From: Carol Reynolds
Sent: 07 June 2018 17:17
To: Anita Gardner
Subject: RE: LU/61/18/PL - 15A Surrey Street, Littlehampton

Site Address: 15a Surrey Street Littlehampton BN17 5AZ

Description of Works: Change of use from A1 (Shops) to use class A3 (Restaurant & Cafe) & A5 (Hot food takeaway) for a 2year trial period

# KITCHEN PLAN.

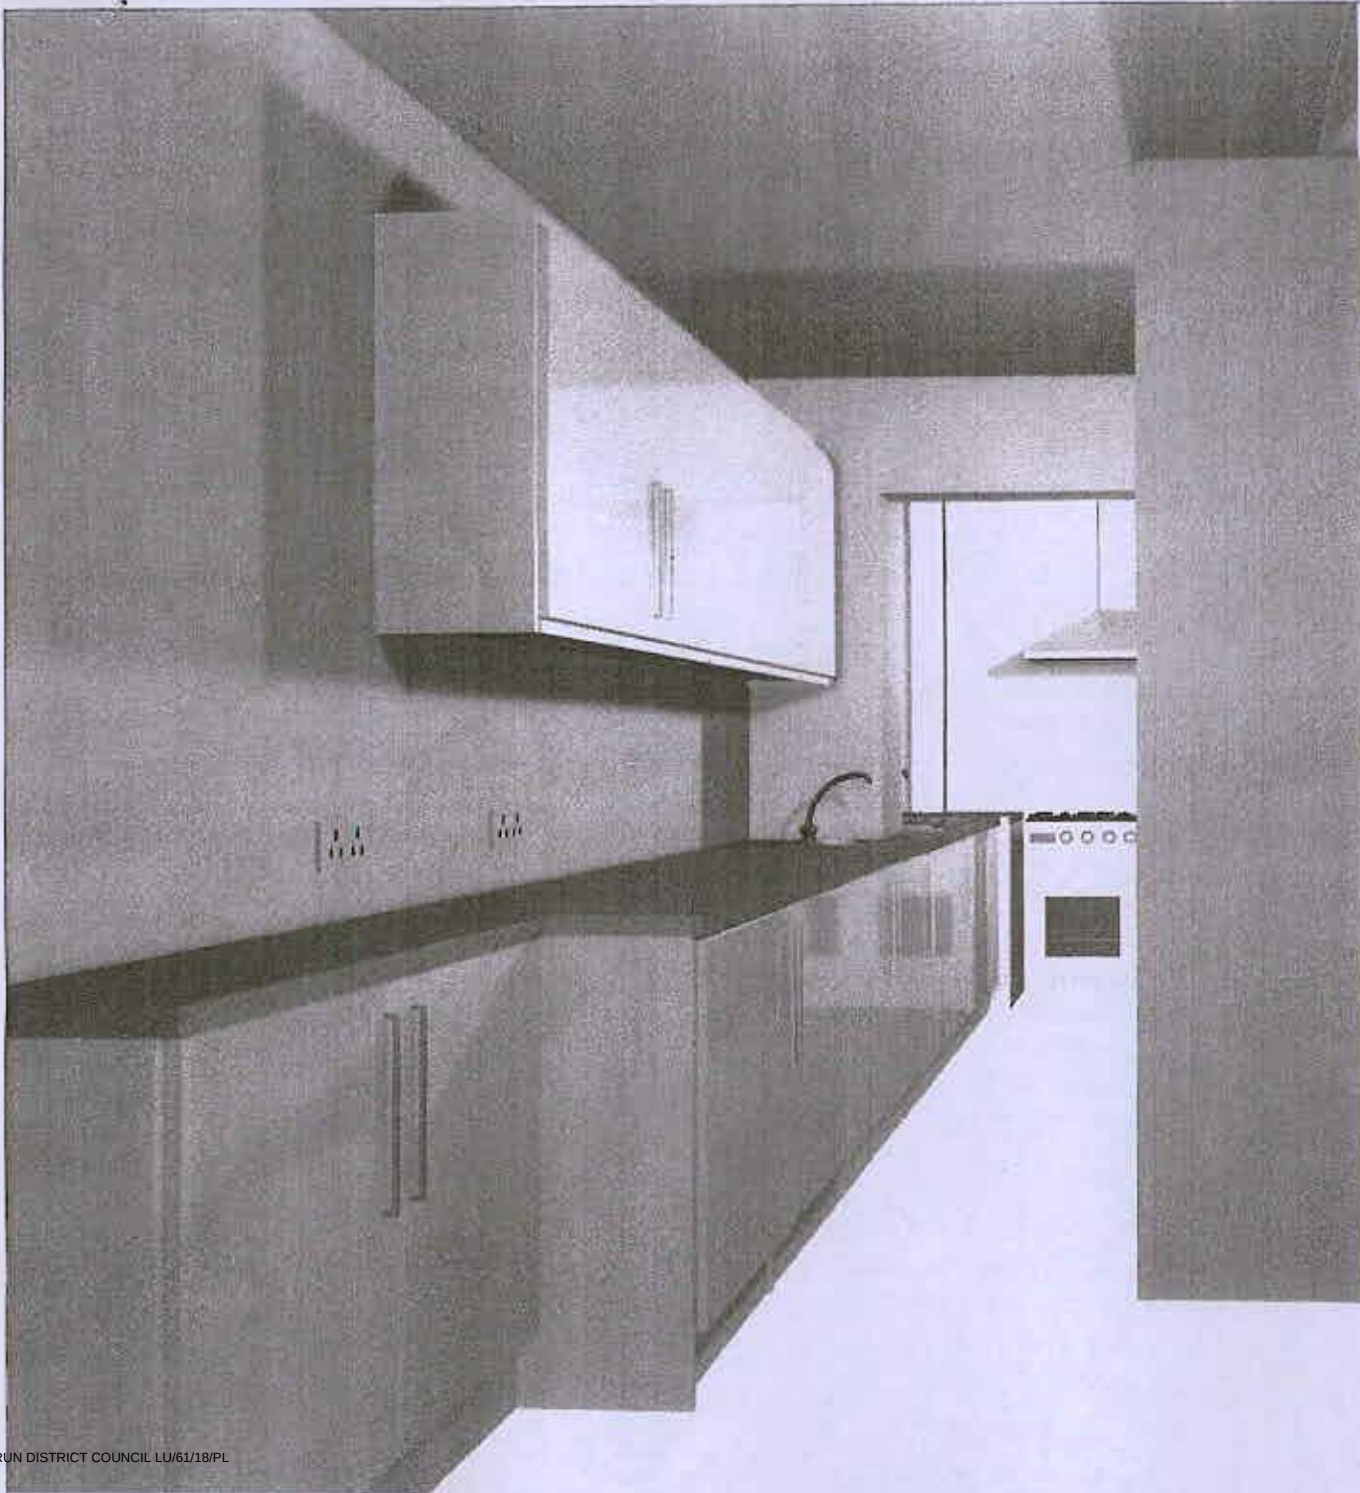
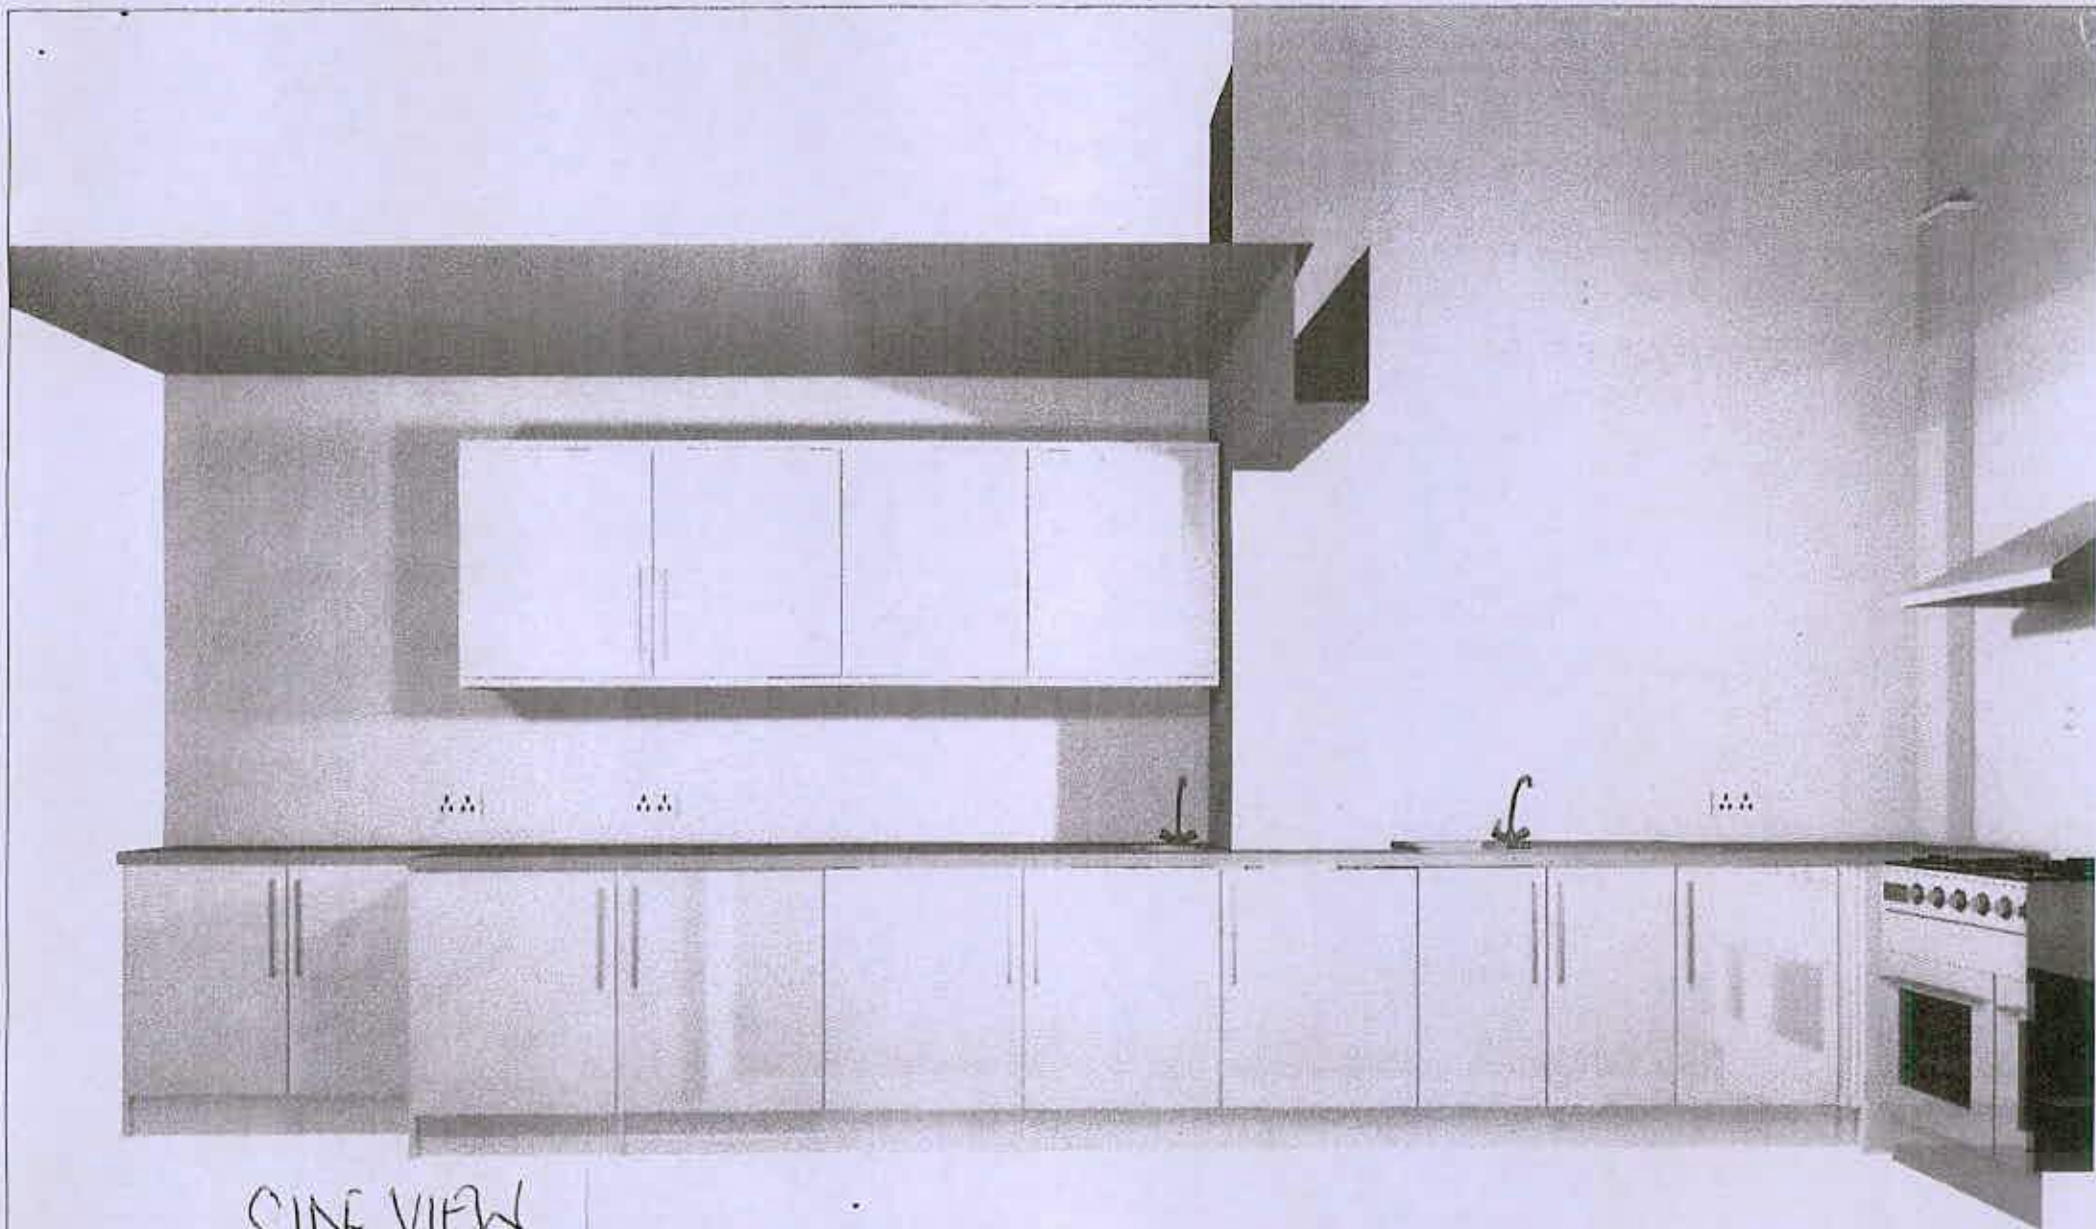
Environmental Health: I understand that Change of Use Class, A1 to A3, has been allowed in this case under the General Permitted Development Order, for an unlimited period of time and only insofar as no cooking or baking and only the reheating of frozen or small quantities of food takes place. The proposed use for the production/sale of Caribbean type foods has the potential to cause odour nuisance to the detriment of surrounding sensitive receptors. I would suggest, as discussed, that the new owner should be provided with a six month trial period to allow the effect of the proposed new use on any neighbouring residential/other units, to be assessed. Should any detriment result, then it may be necessary for means of mechanical ventilation together with odour abatement to be provided. Such a system would be required to vent at eaves level, or 1 metre above the level of any openable window. In this case then it would also be likely that an Acoustic Report would be required to detail the means by which this system will also protect neighbours from intrusive noise.
